Rebuttal to National Grid document 9.34.6

Plate 2.3 Infrastructure within fluvial flood extents

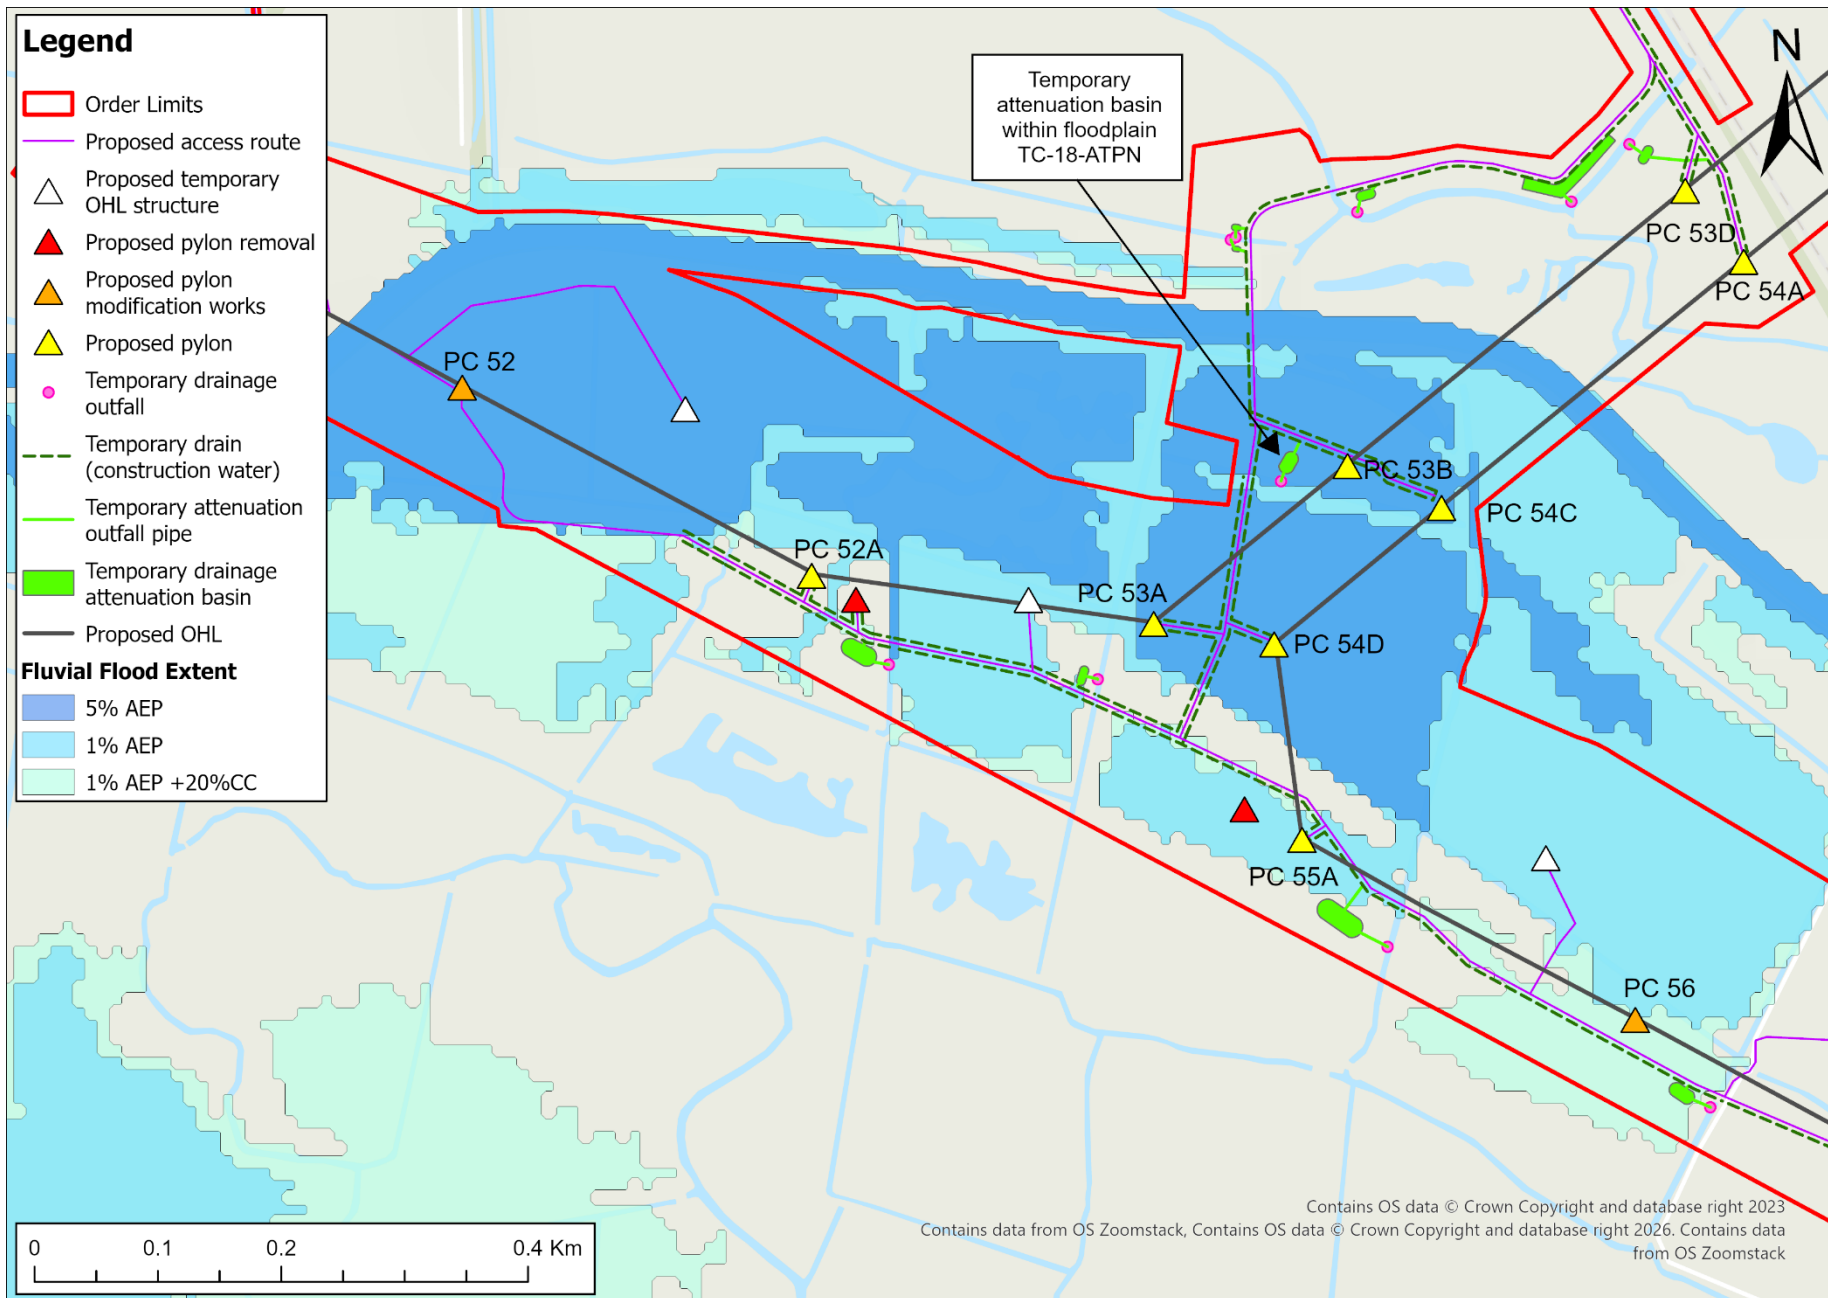
7.1.3. Full details on reinstatement approved by a alluvial clay soil specialist to confirm that farmland can continue to operate after construction traffic and temporary attenuation ponds.

Access route for construction traffic along banks of River Stour inadequate, confirmation required.
